Case number ABP-319866-24

Case ABP-319866-24: North Irish Sea Array Offshore Wind Farm. Submission on the further information

“Submission on the further information”

North Irish Sea Array Windfarm Limited
on the North Irish Sea Array (NISA) offshore wind farm.

Figure 3.2: Surface Swept Area Ratio 2016 to 2020 for EU (including UK) vessels ≥ 12 m length using demersal otter trawl gear (Source: ICES, 2021)

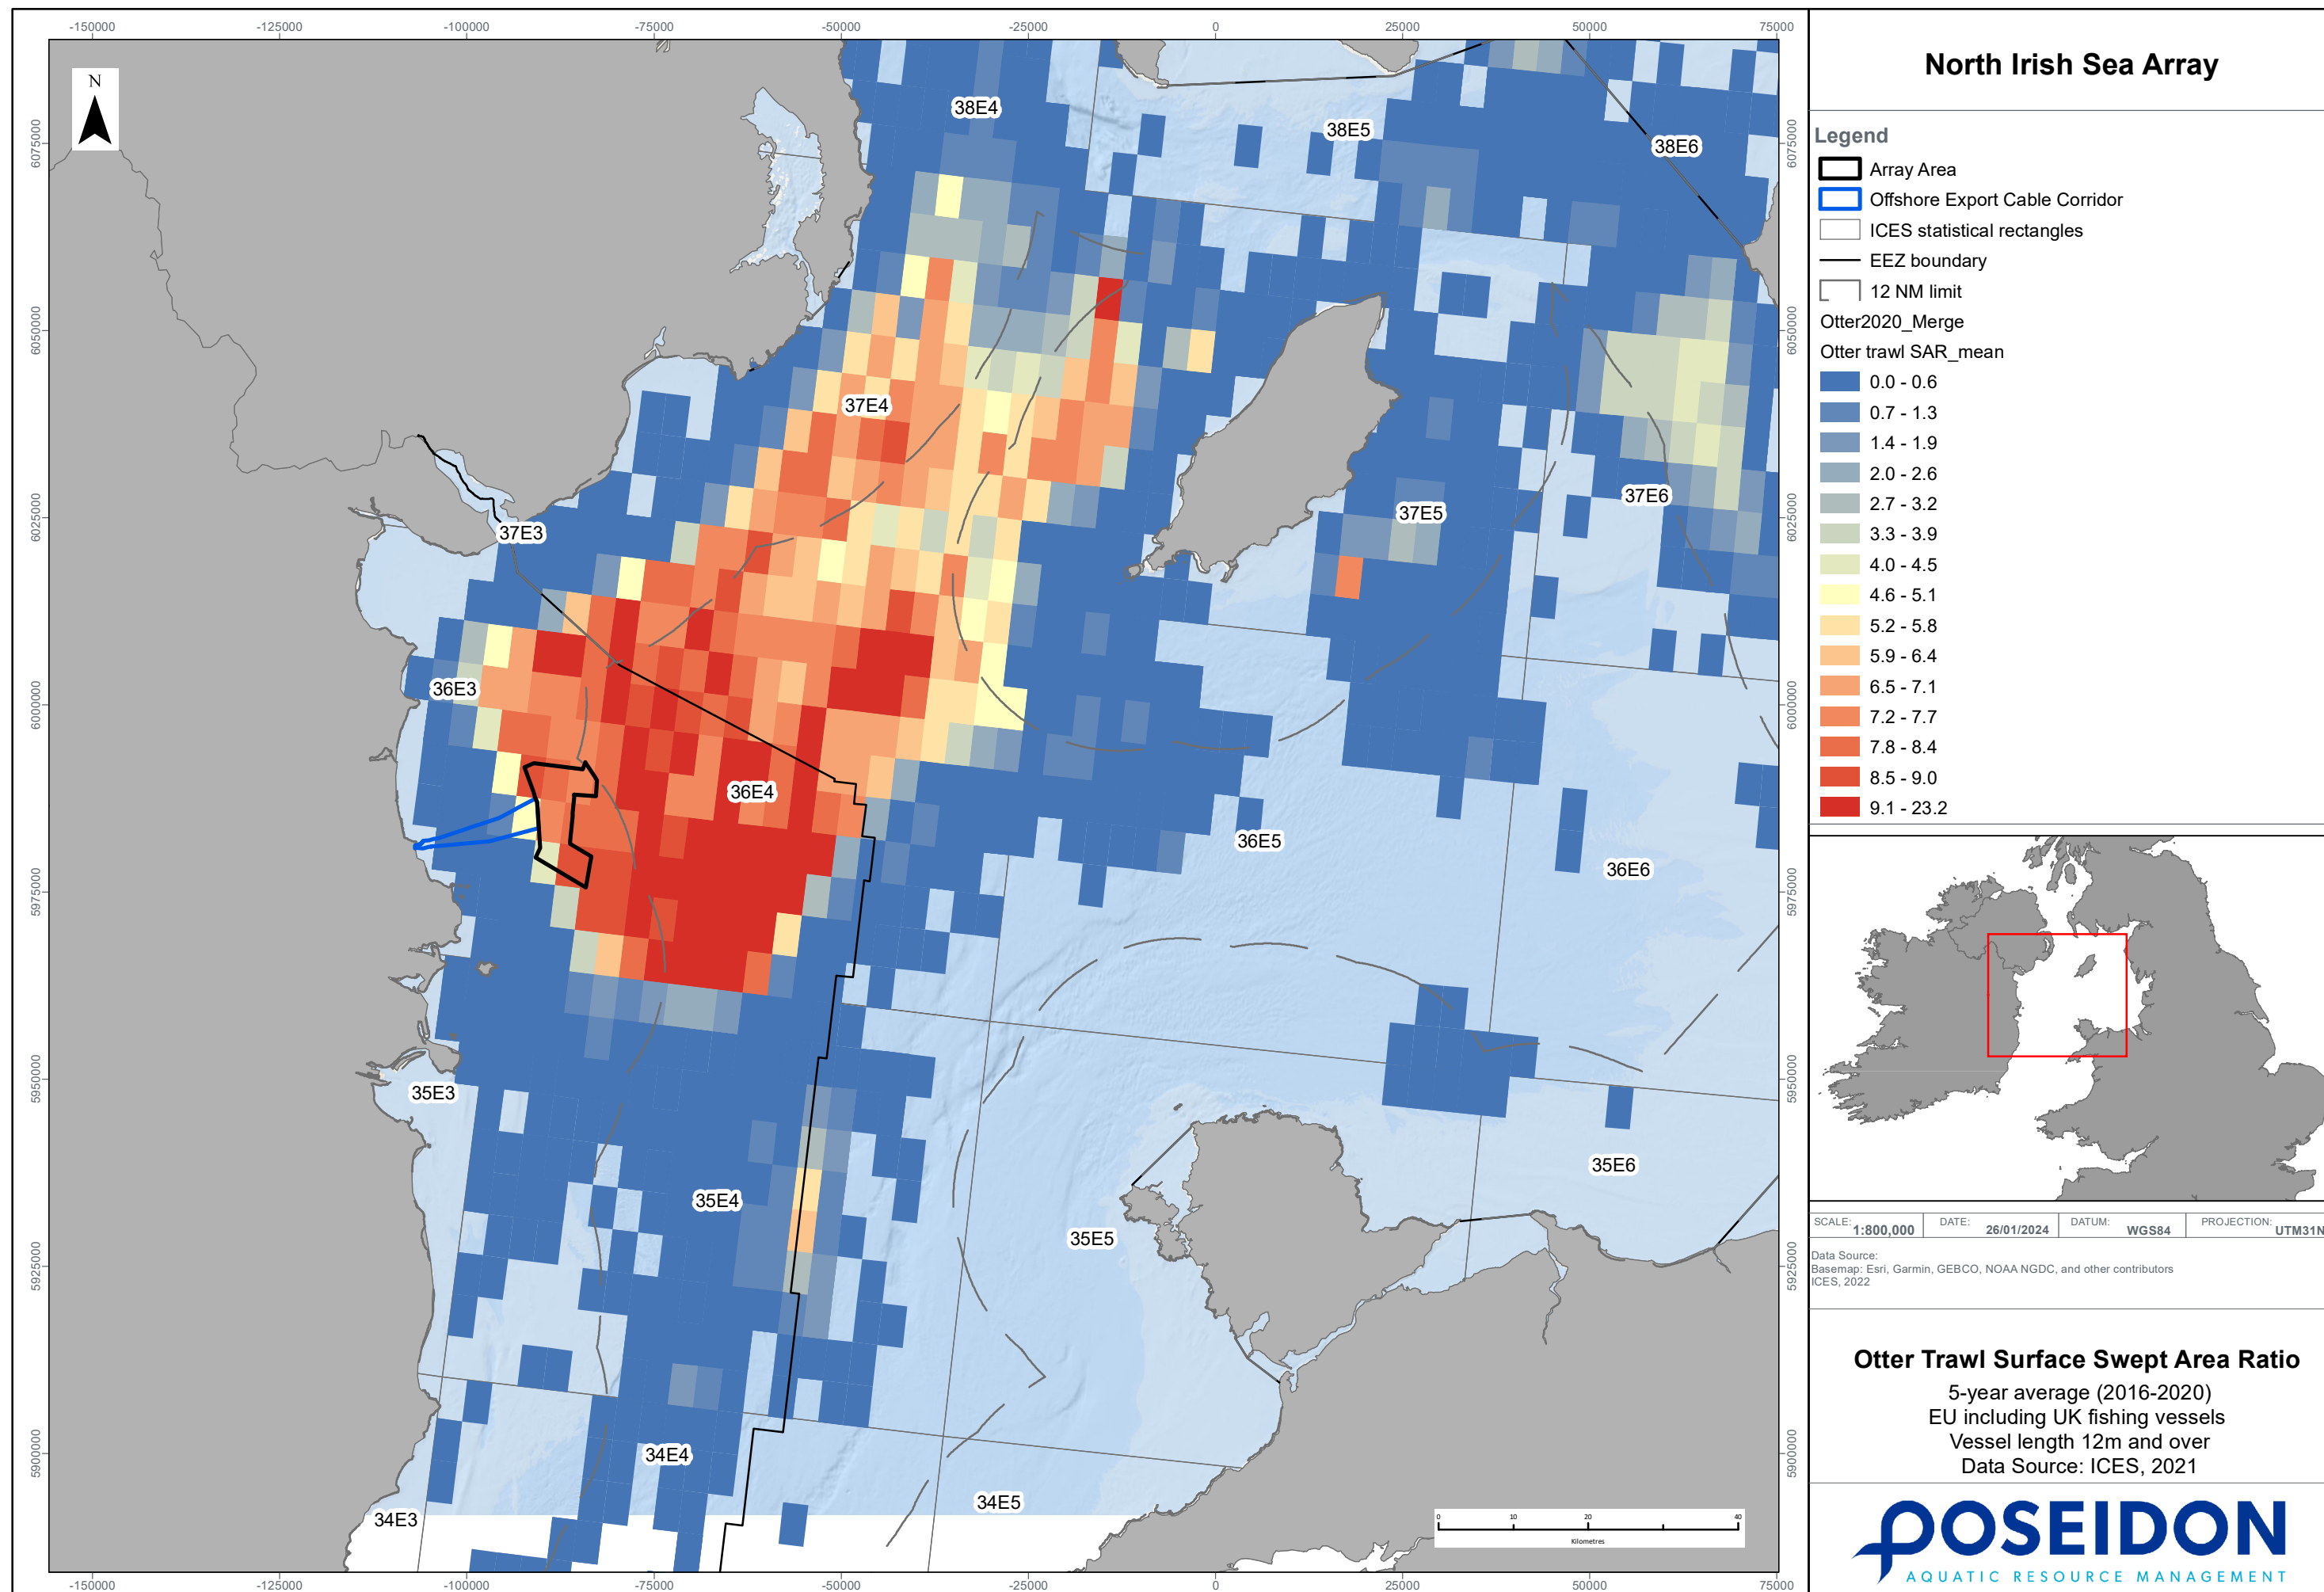
- **Spatial evidence.** The location of the fishery, and the share of it lying inside the array, rest on surface swept area ratio data for 2016 to 2020 (Addendum Table A16.1). Rectangle-level landings data run only to 2021 or 2022 (Appendix A16.1, Table A2.1).
